## REITER ARCHITECTURE & DESIGN

**Subject:** Re: 227 York Street - details reviewed 4/25

Jeanie, as always, thank you for spending the time with me to go through some of the specific code interpretations regarding the proposed project at 227 York Street. Central to the discussion is the basic understanding that this is a residential R-3 building, but it is permitted to have a ground floor commercial occupancy within the building, by virtue of the lot's zoning. Per our telephone discussion today, I understand the following:

A1.3

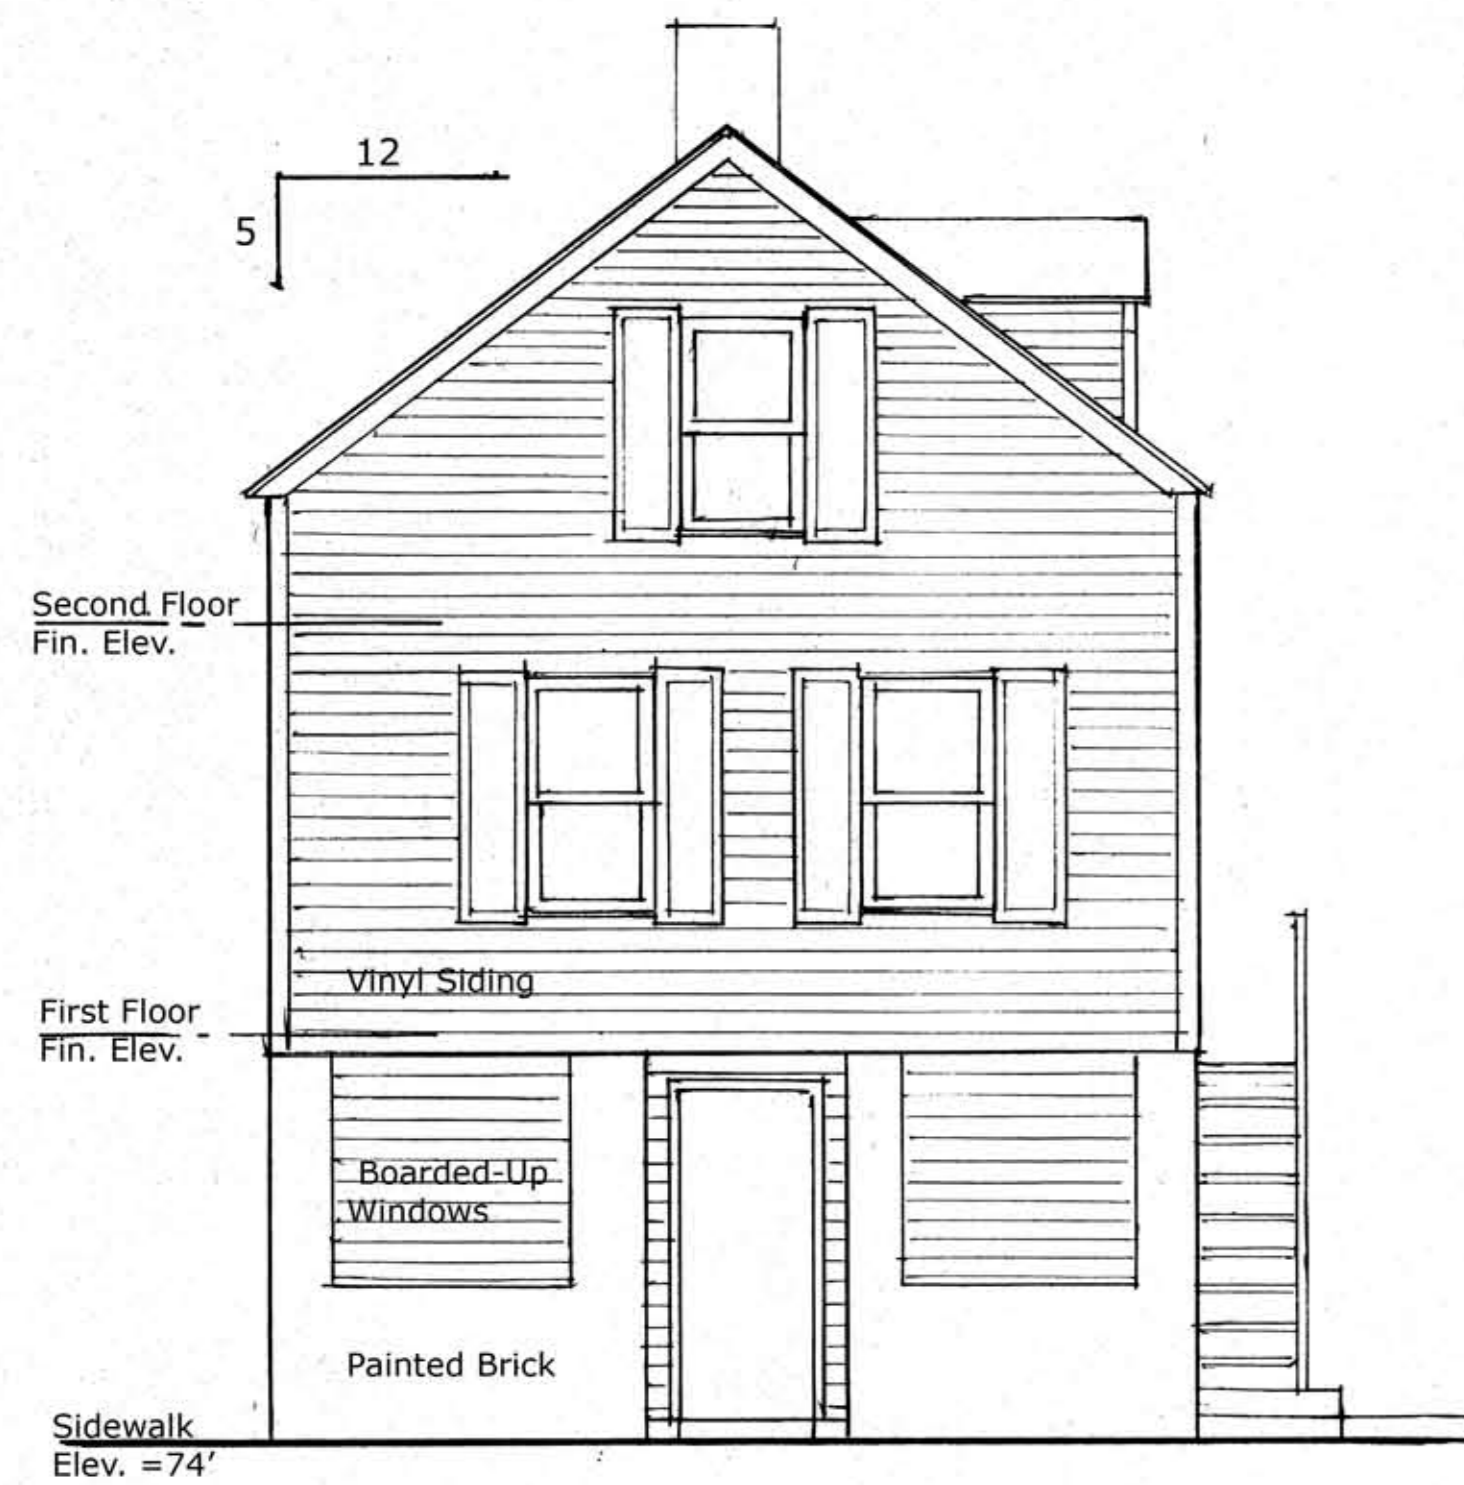
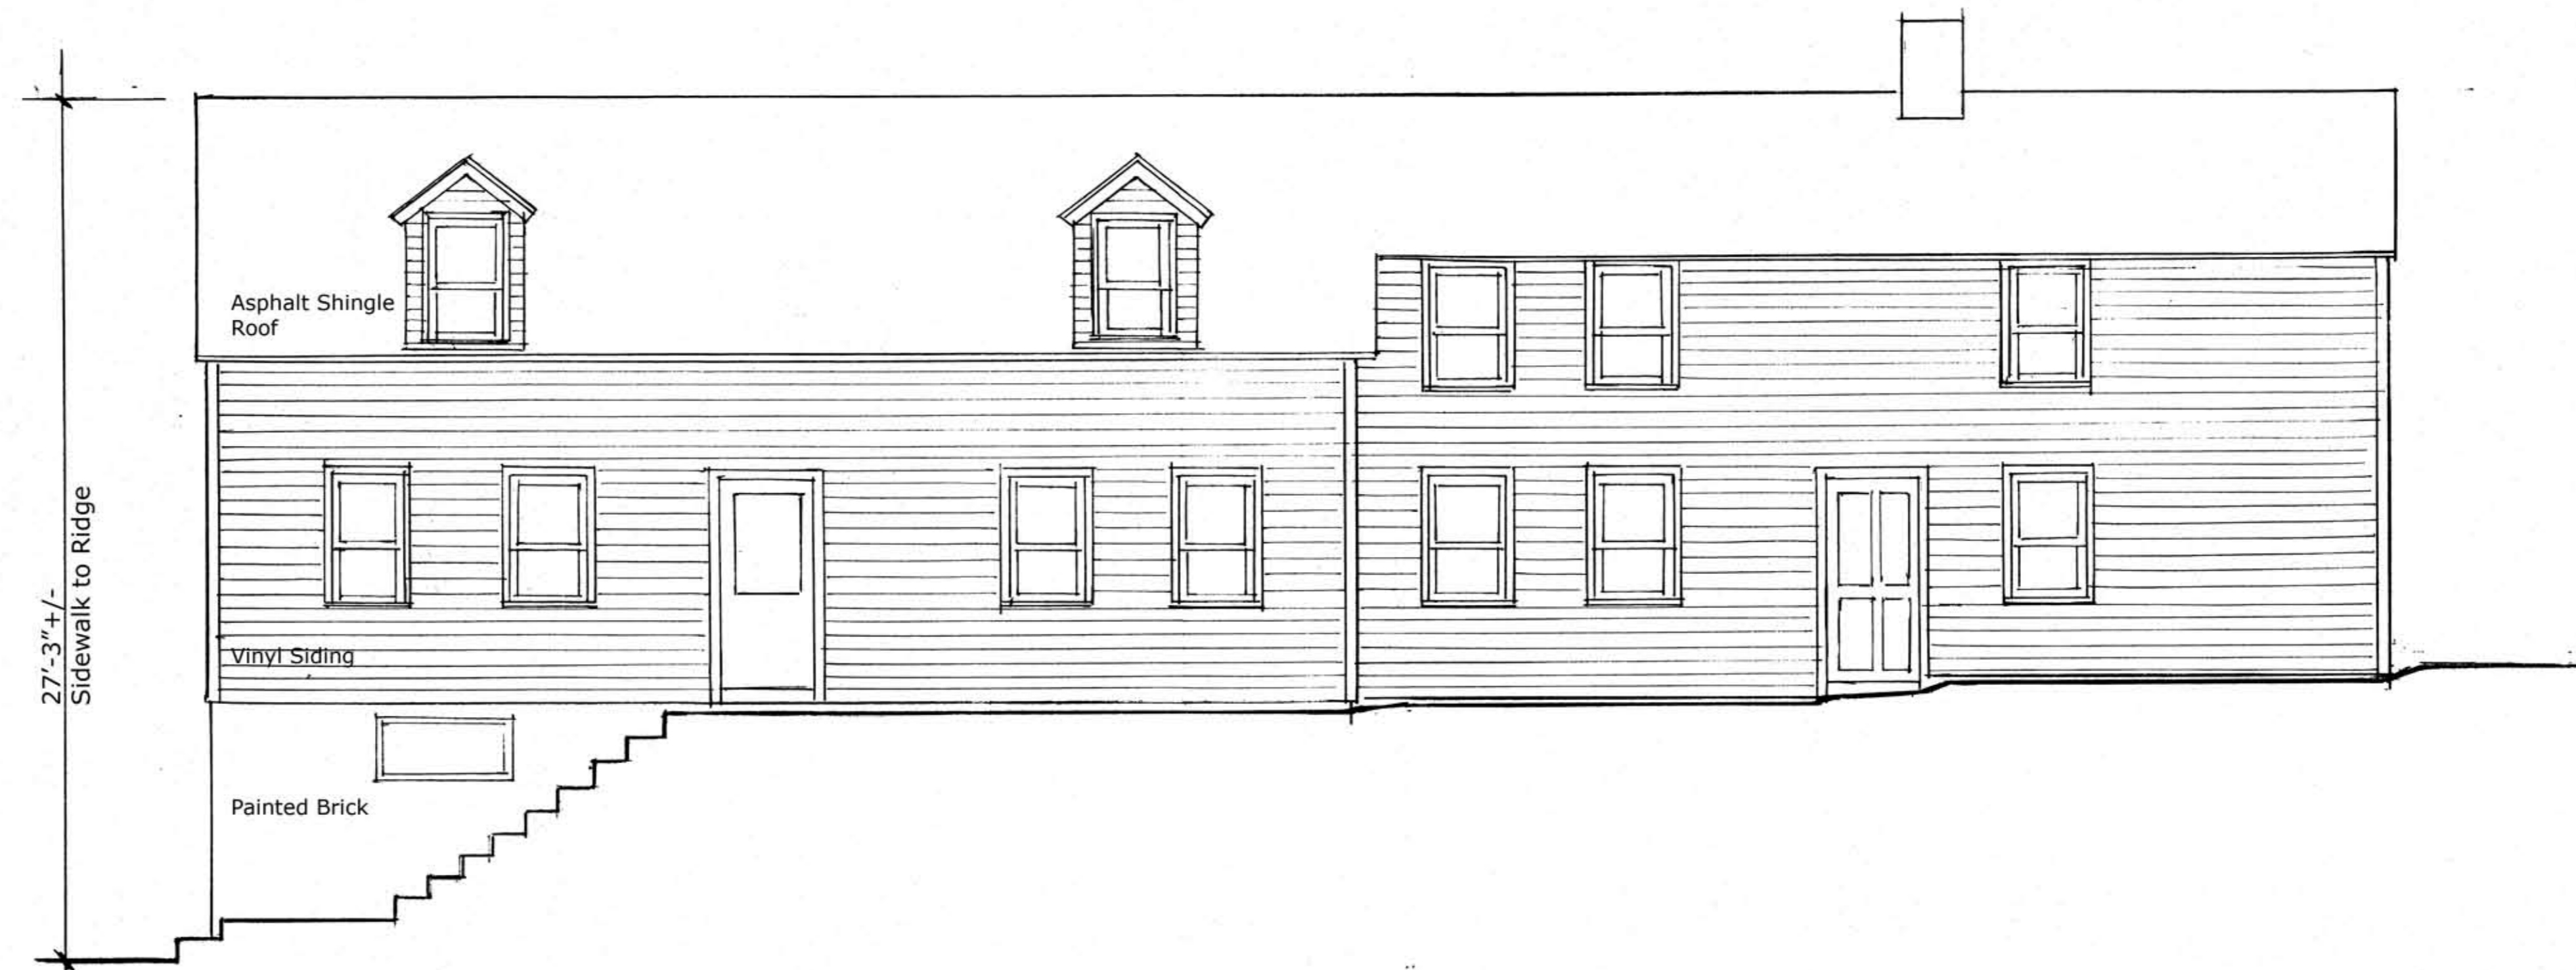
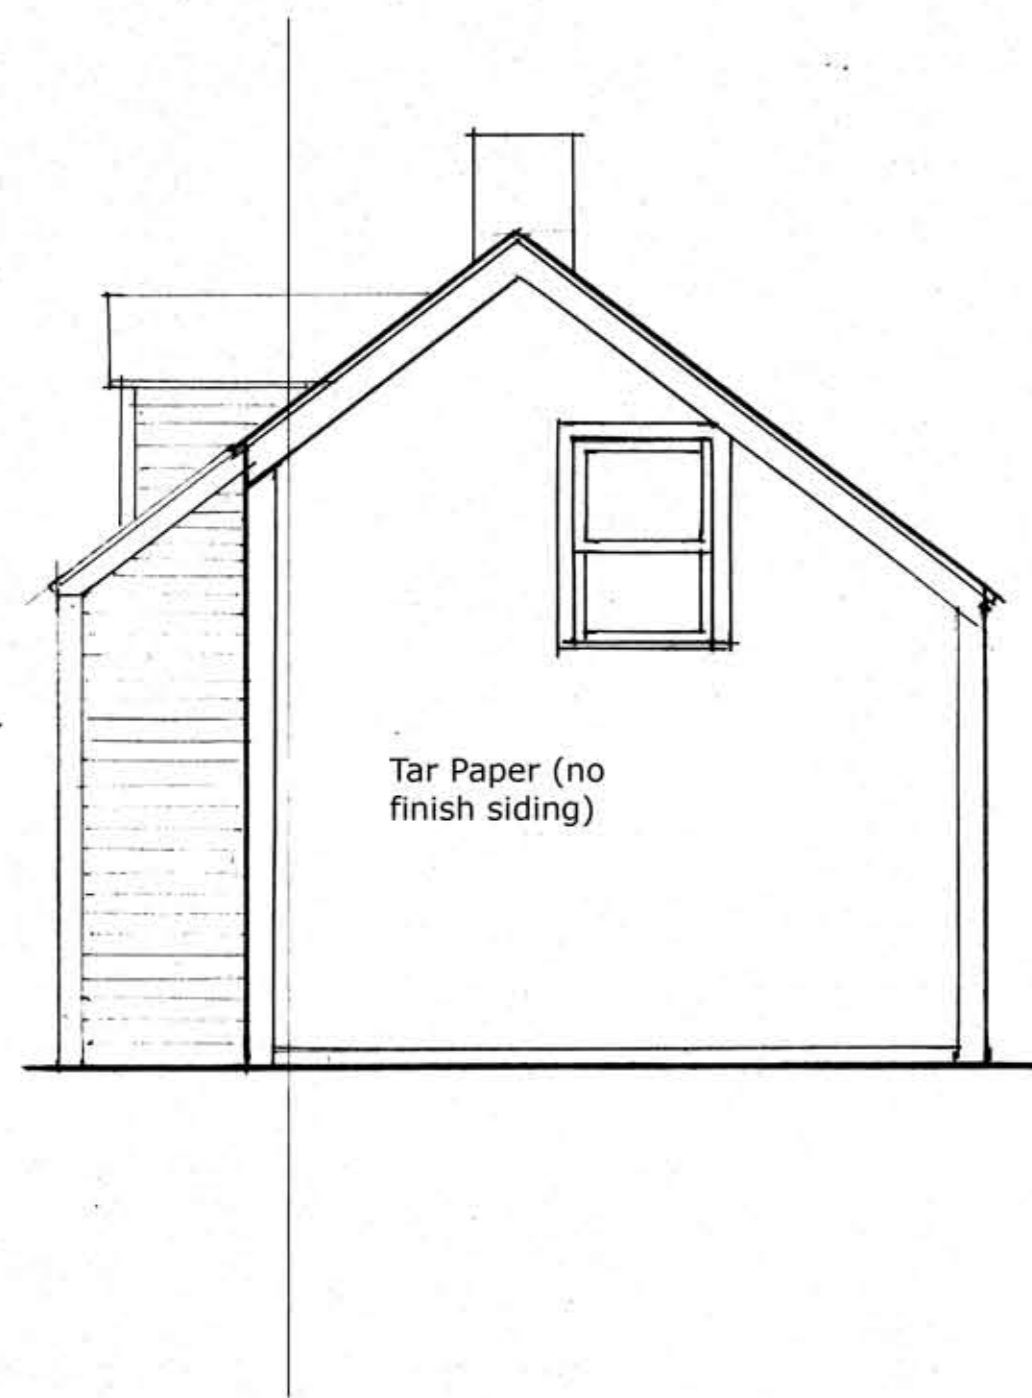
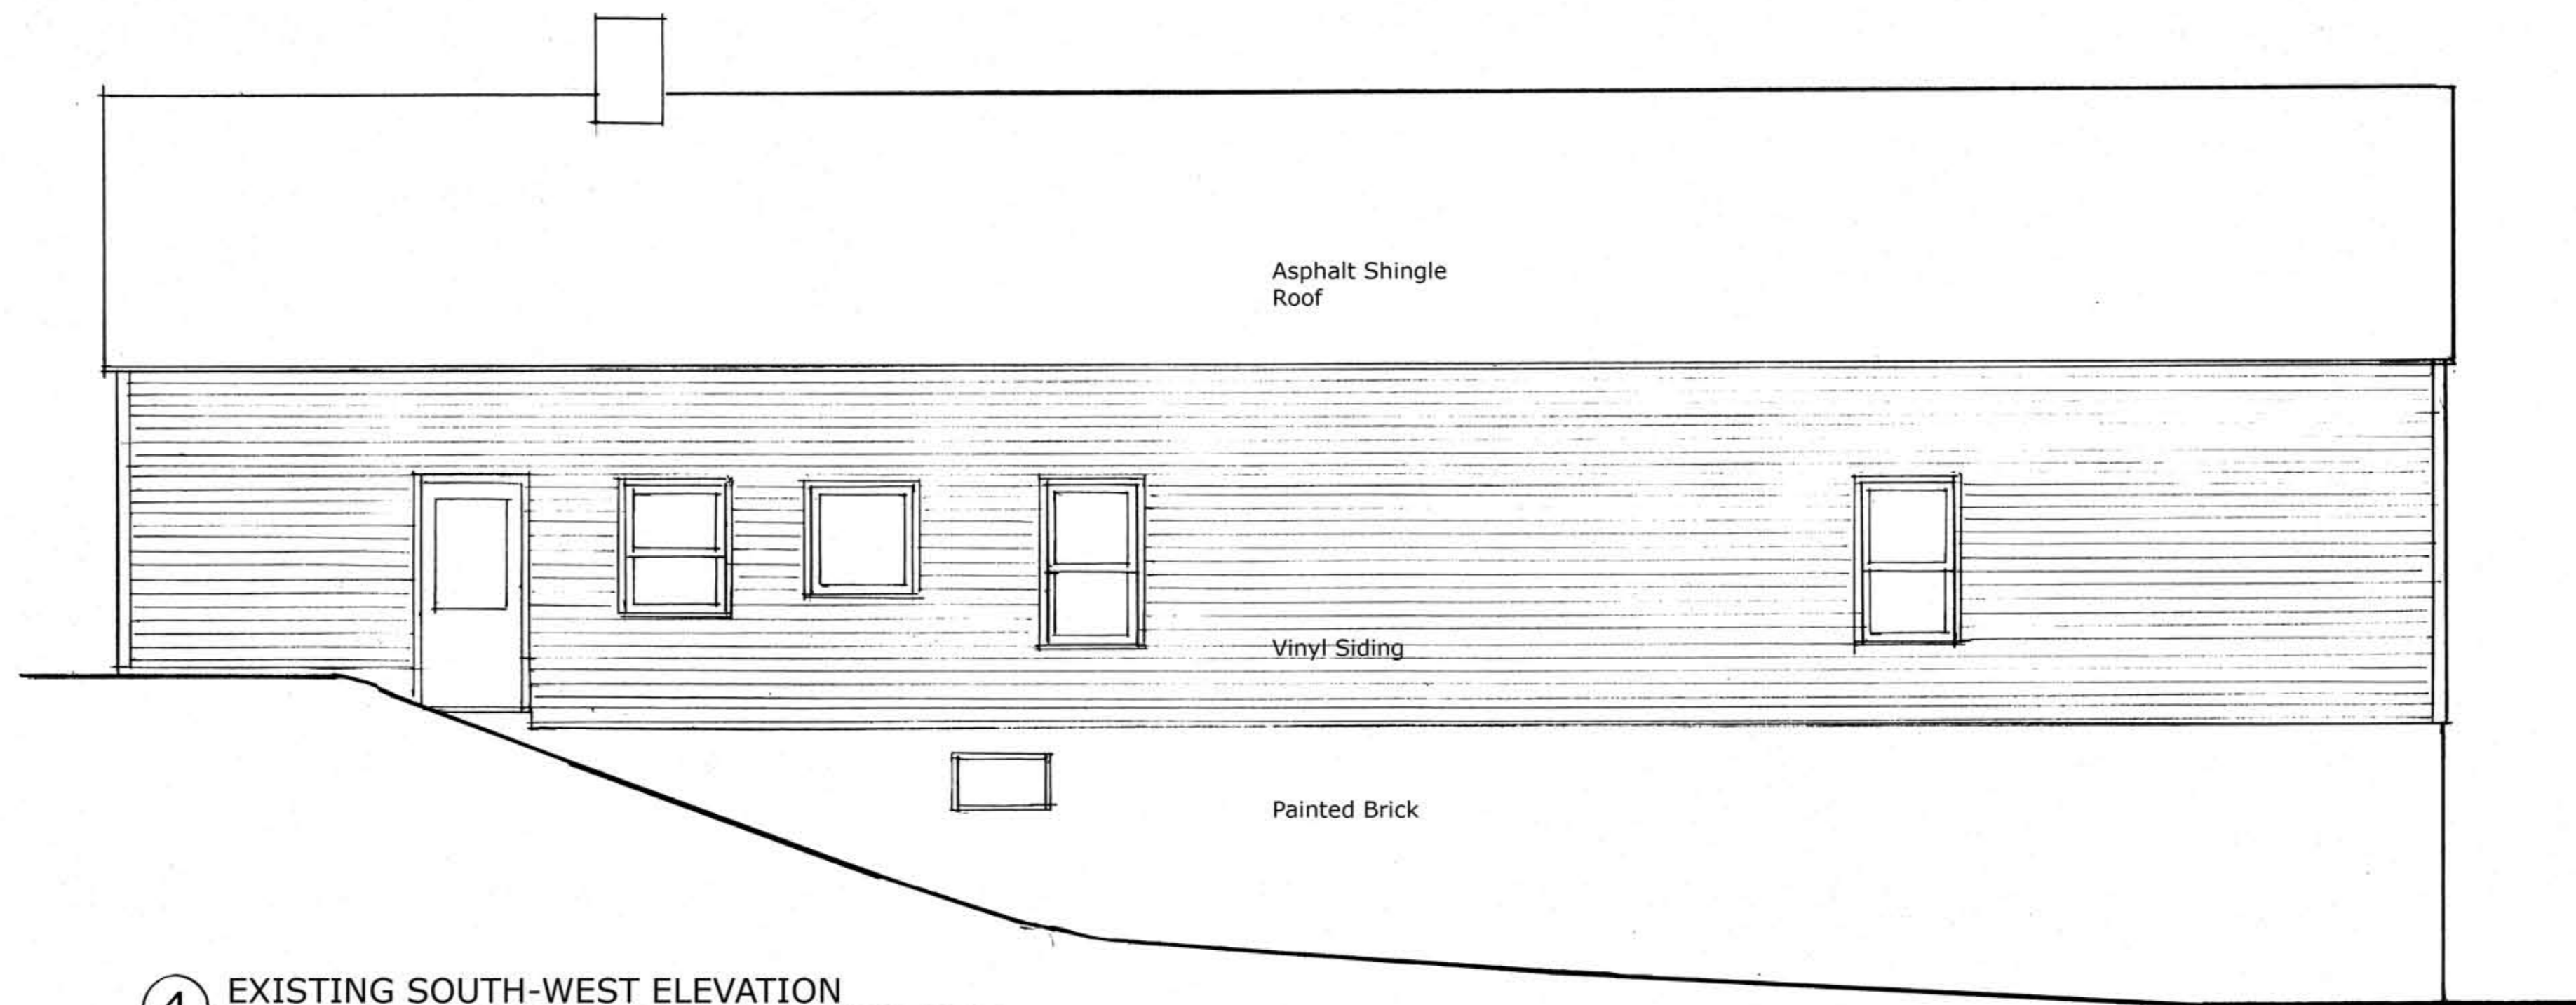
2. **Lot Line Windows:** Lot Line windows will be accepted, provided that the amount of window area on this wall does not exceed that of the original, existing building, and provided that each window on this wall has a sprinkler head directly above it at the interior. **Correct, this is acceptable, please provide the existing and proposed window glazing showing percentages at each level.**
